Erection of 2 No. 3 bed dwellings, demolition of existing garage & shed & erection of new car port. Resubmission following R/305/14/PL. This application affects the character & appearance of the Station Road Conservation Area.

Land to the south of The Tiled Barn Station Road East Preston

Thank you for your internet representation made on 2nd September 2015 which has been recorded as '**an objection**' with the comments as follows:

REVISION		
PROJECT		
Proposed development on site adjacent to Tiled Barn, Station Road, East Preston		
SUBJECT		
Plot 1 - Proposed Plans and Elevations		
SCALE	DATE	DRAWING No
1:100 @ A2	June 2014	2014 / 32 / 11
DRAWN	CHECKED

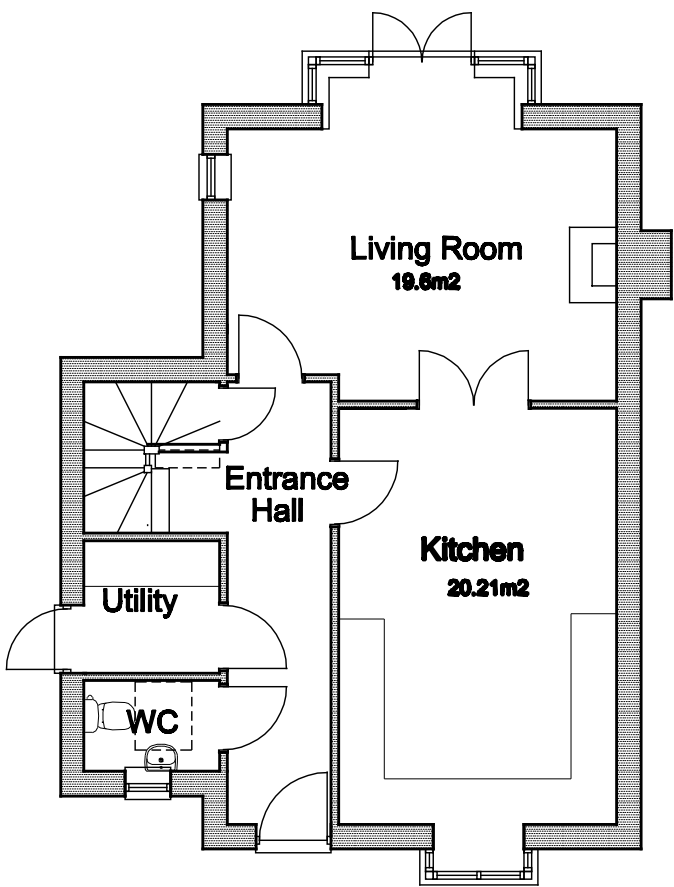
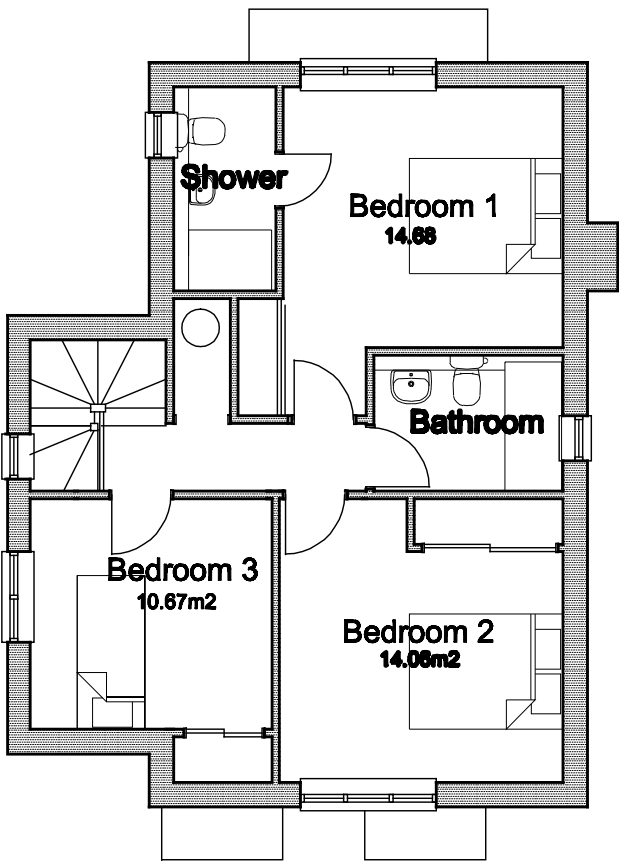
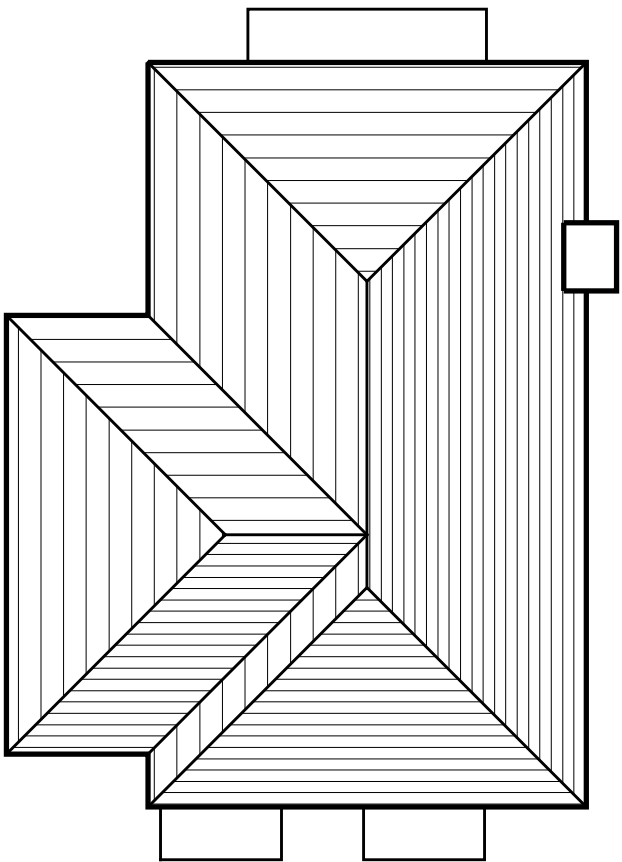
The two proposed houses are depressingly familiar in general design from the buildings on any large modern development. To accommodate two detached houses on sites which are too narrow for a well-proportioned house of this type, they are too narrow for their height. This design weakness creates essentially unattractive buildings, which in no way could be said to preserve or enhance the character or appearance of the area, including its setting, as Policy HER SP1 of the Publication Draft of the Arun Local Plan requires. The addition of patches of flint facing cannot compensate for the deficiencies in the basic design of these houses.
